Interested Party Reference: 20047795

27th November 2024

**Mona Offshore Wind Farm:
Response to ExQ2: 19 November 2024 on Behalf of Tan-y-Mynydd Trout Fishery**

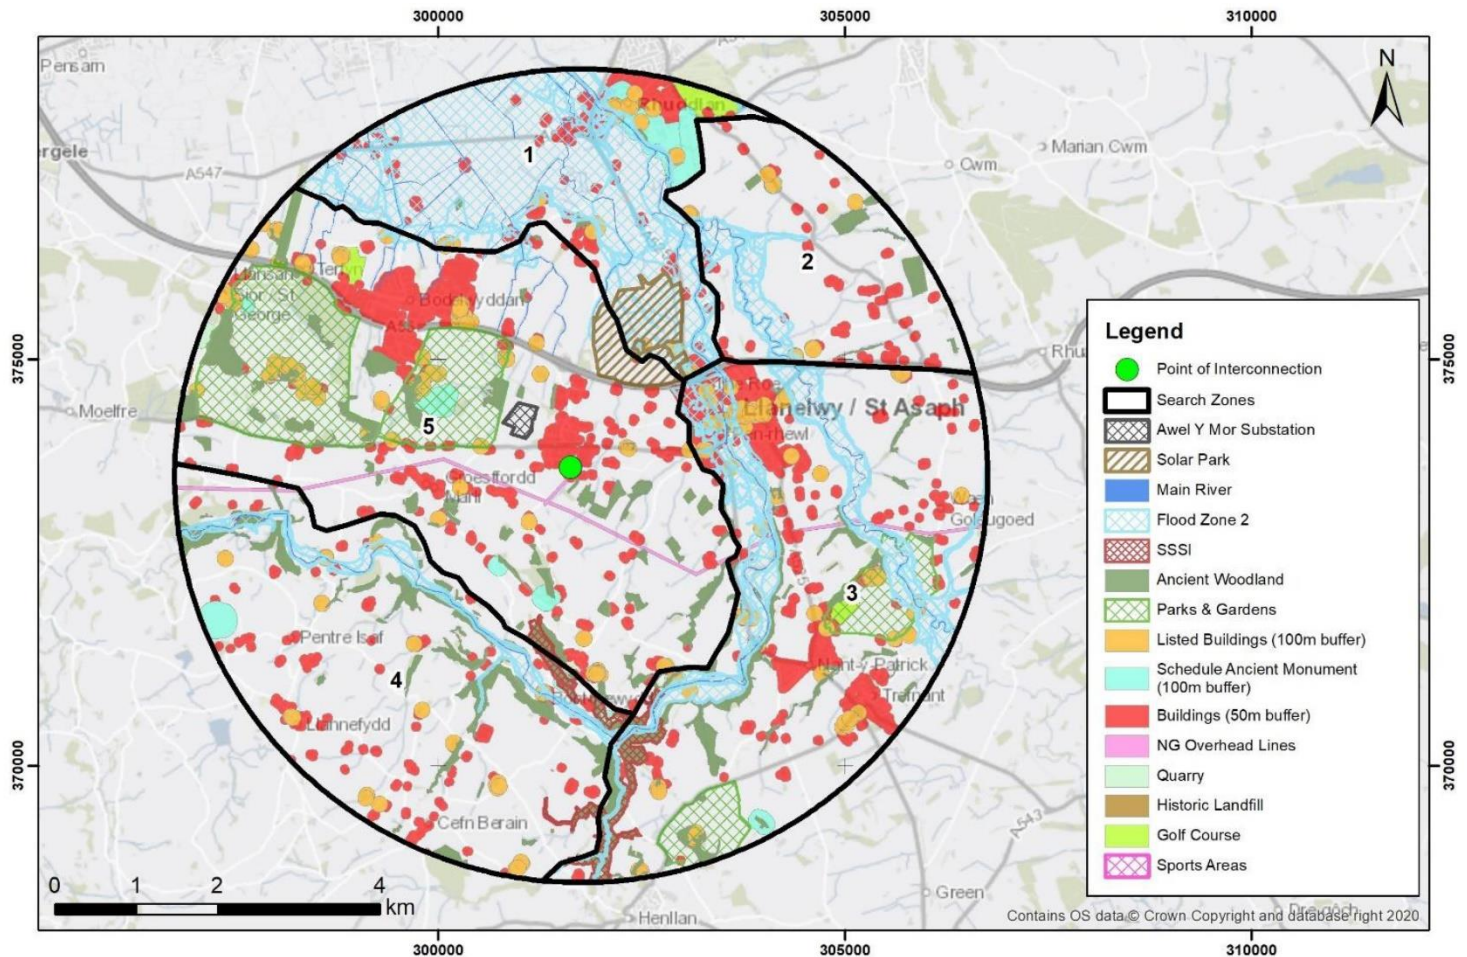
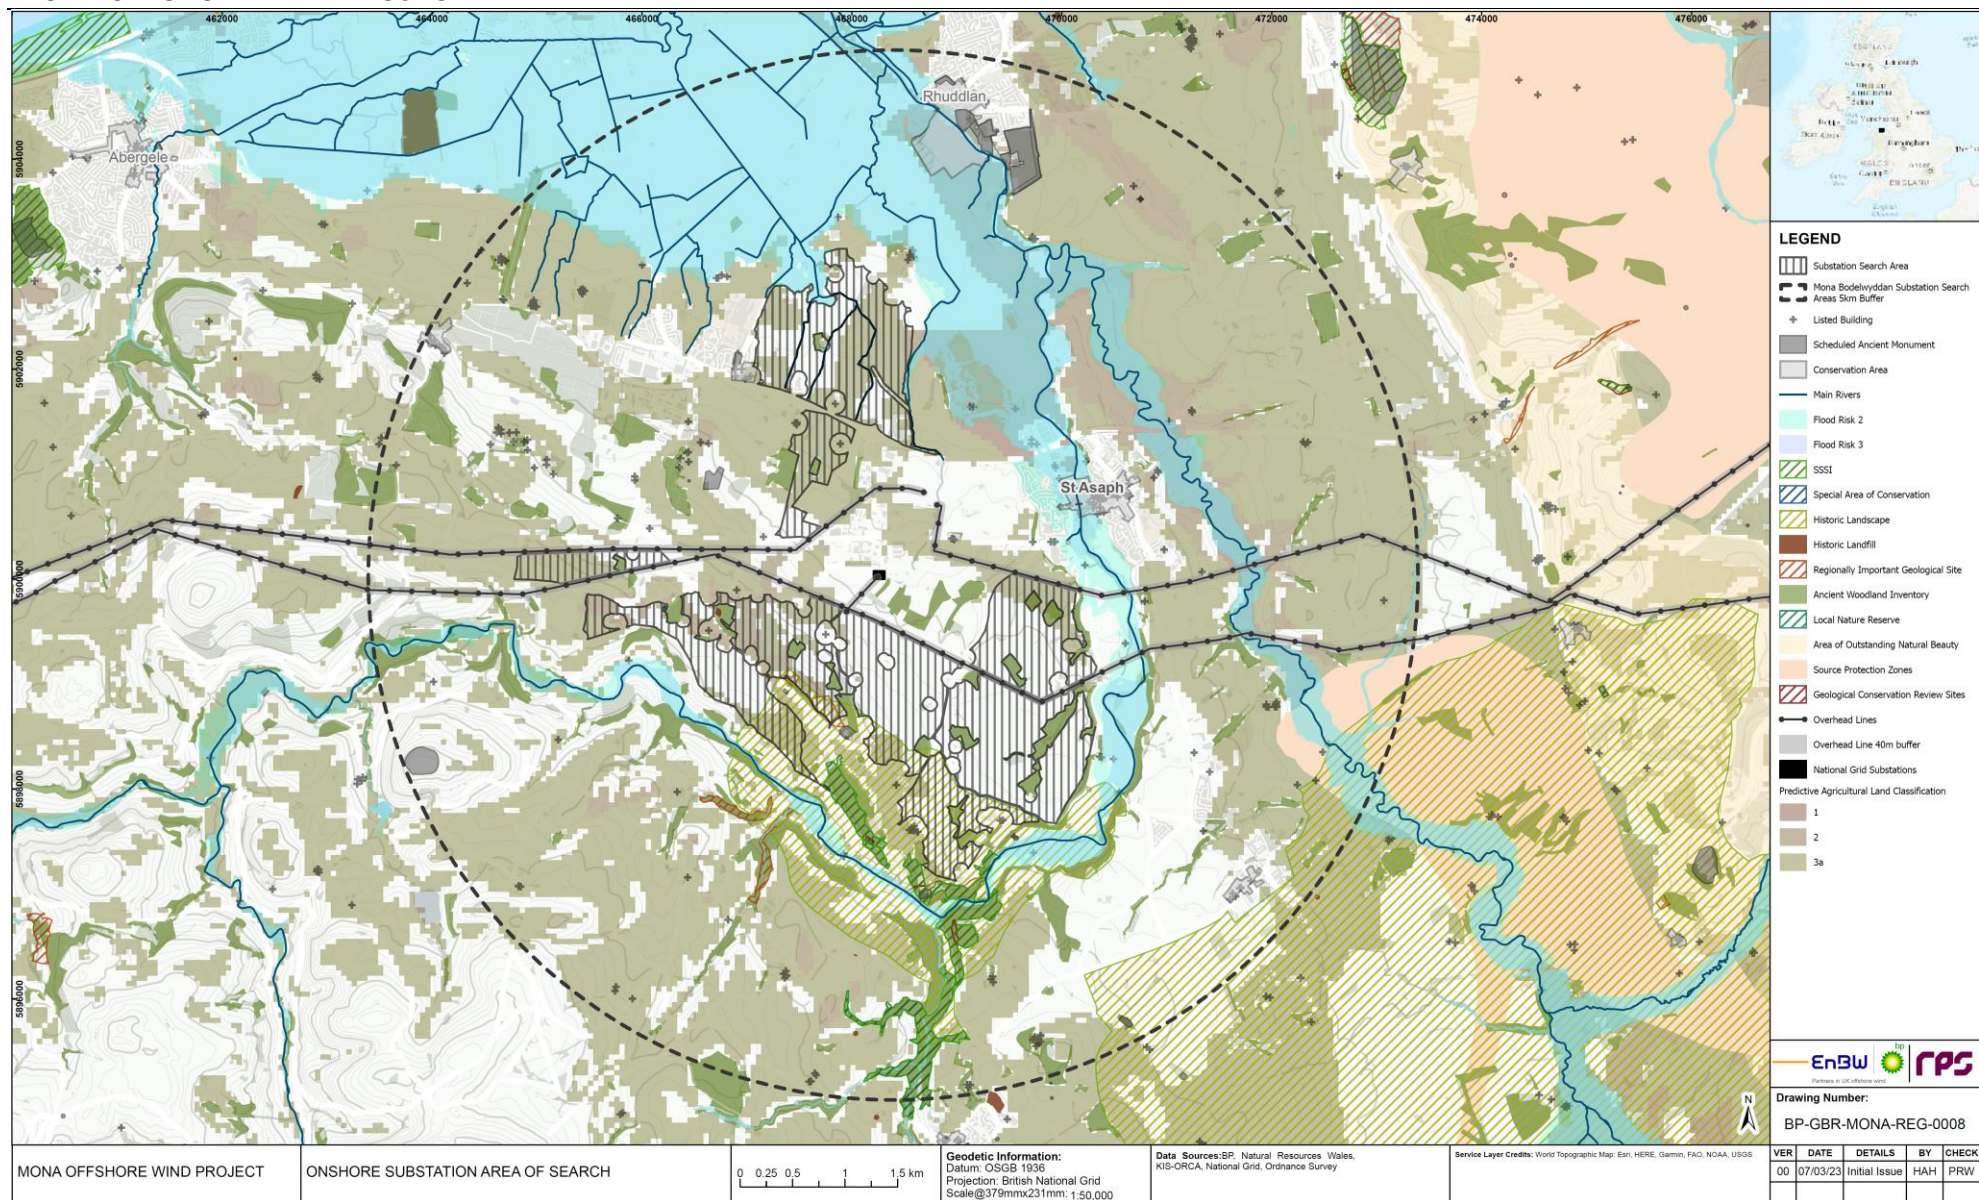
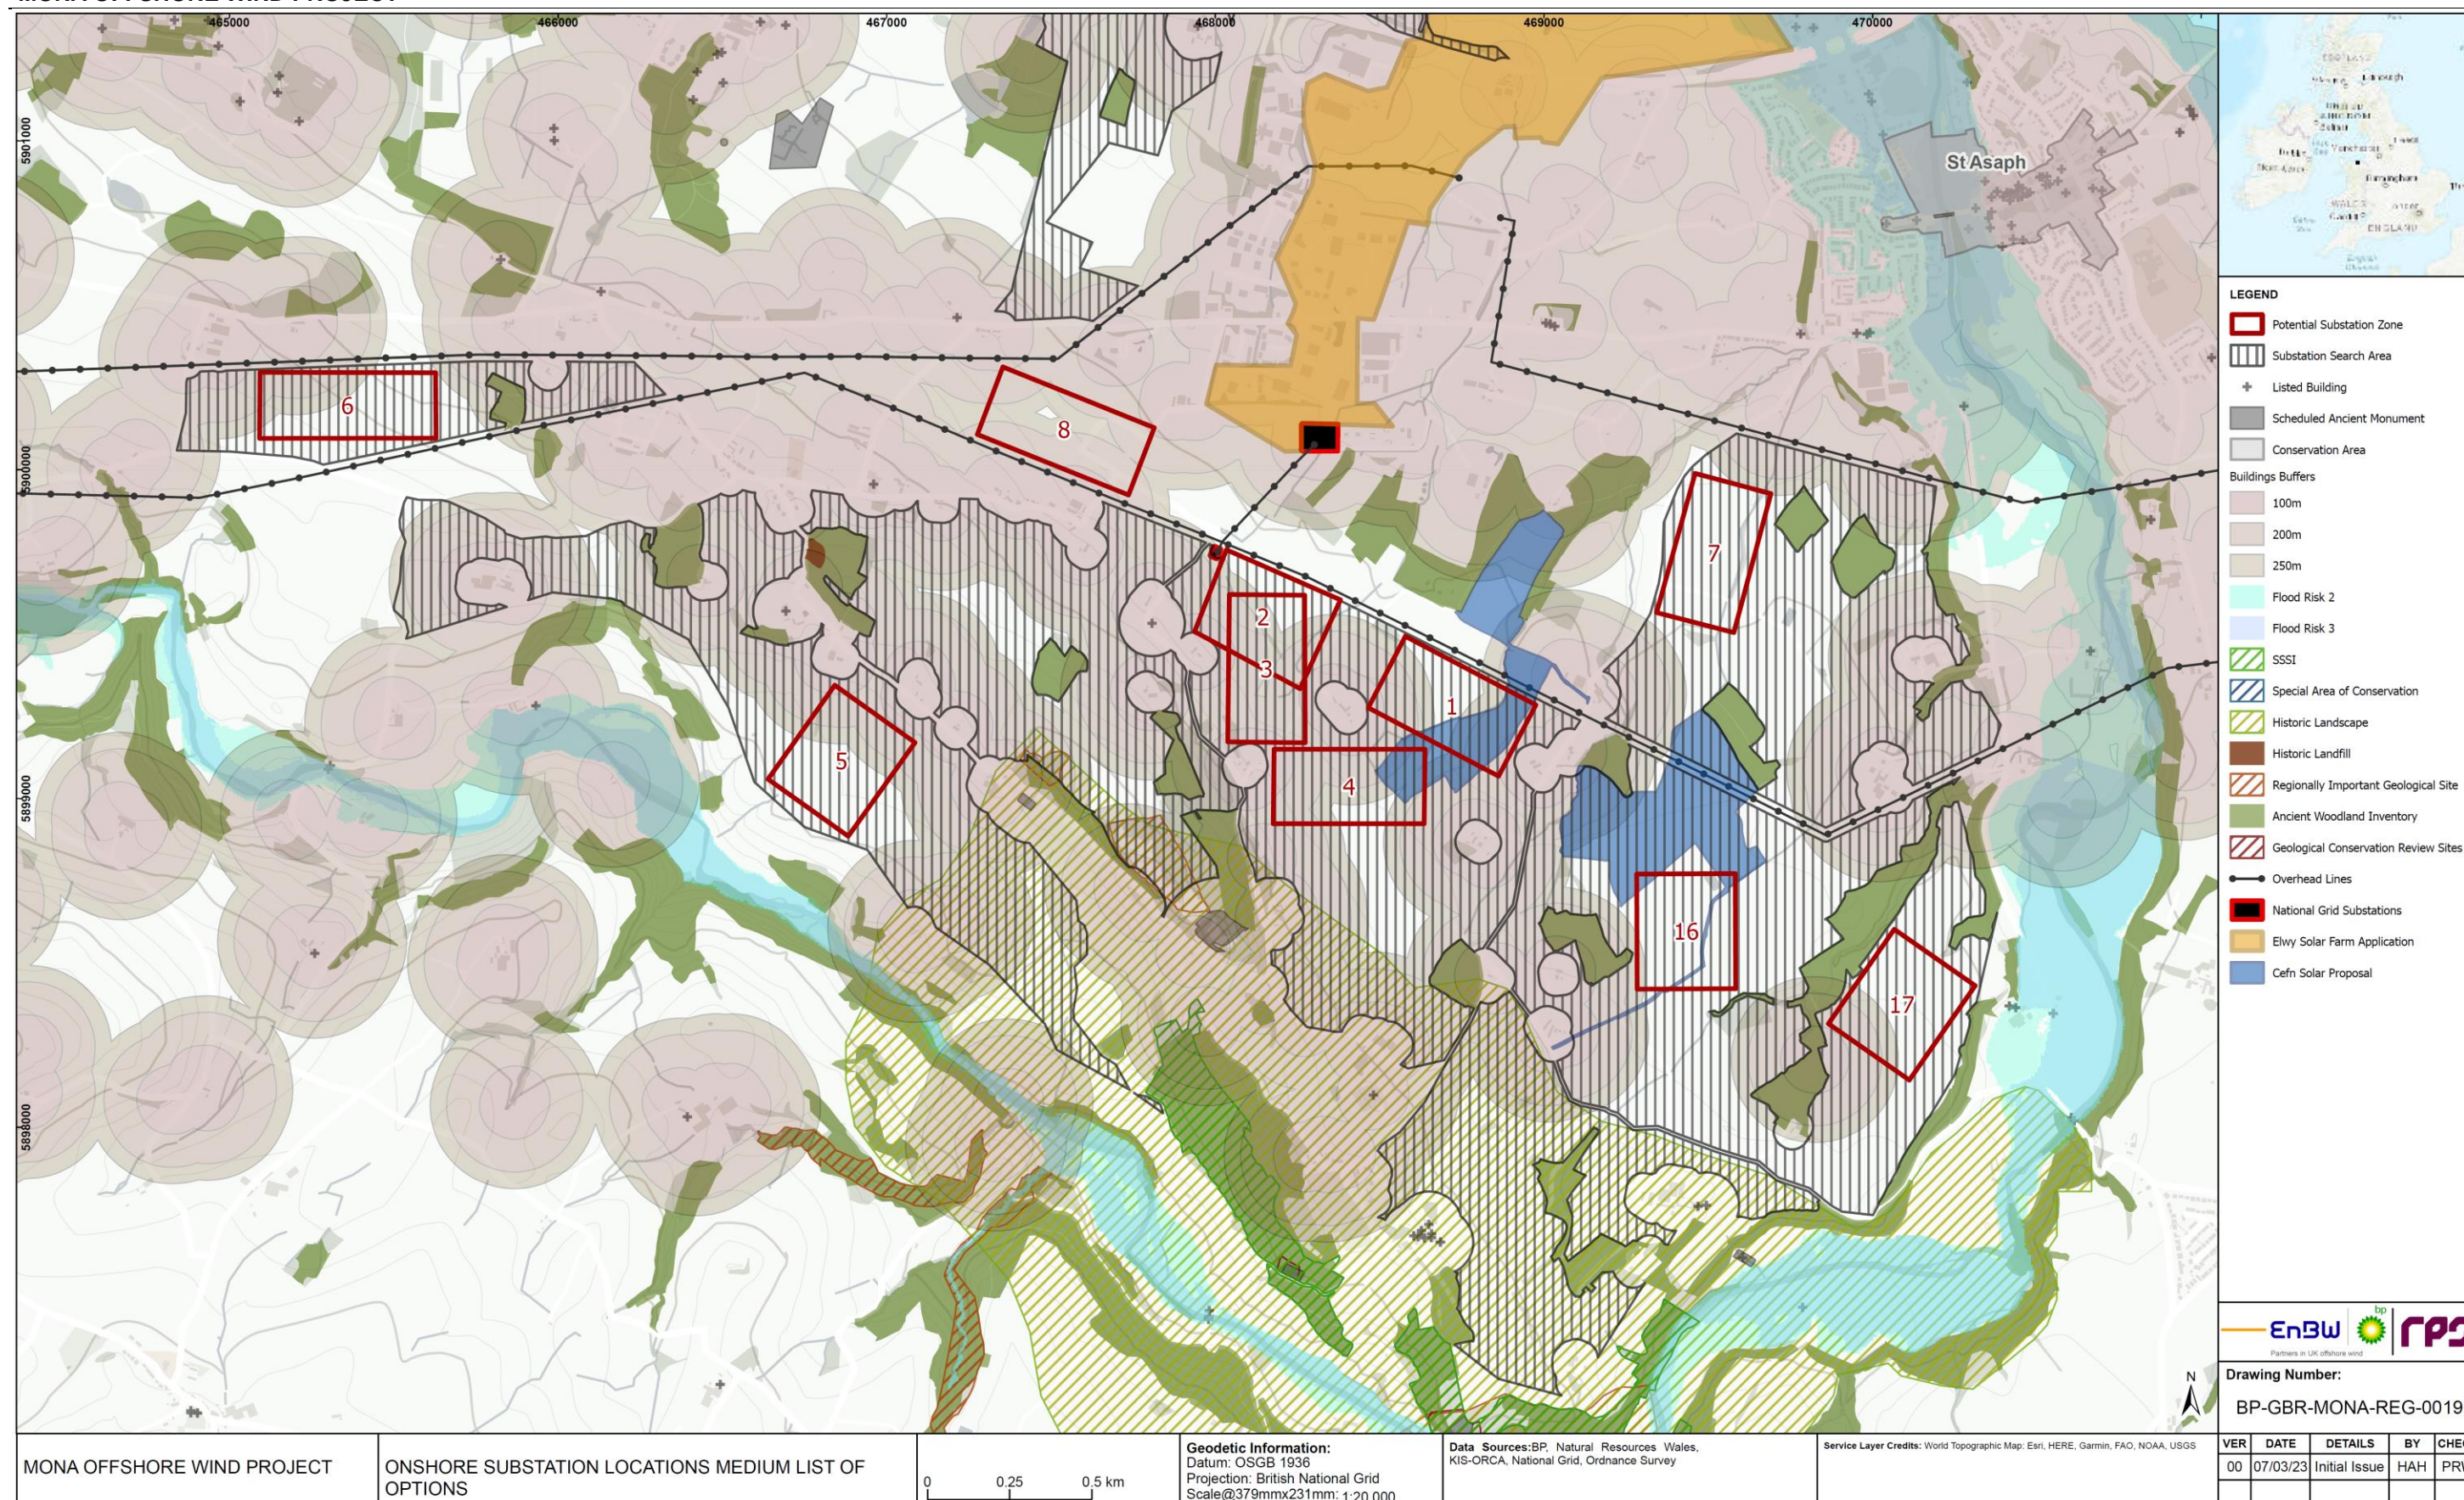
Rep3-107.01: The BRAG report has been received. Sadly, it is very light and 'very subjective', in its consideration of the impacts on the water sources enjoyed by the fishery. This is particularly the case regarding it adopting the Southern cable route. Indeed, based on the overall BRAG report, we would venture that the fishery water sources were at best an extremely minor area of consideration in the grand scheme of route selection.
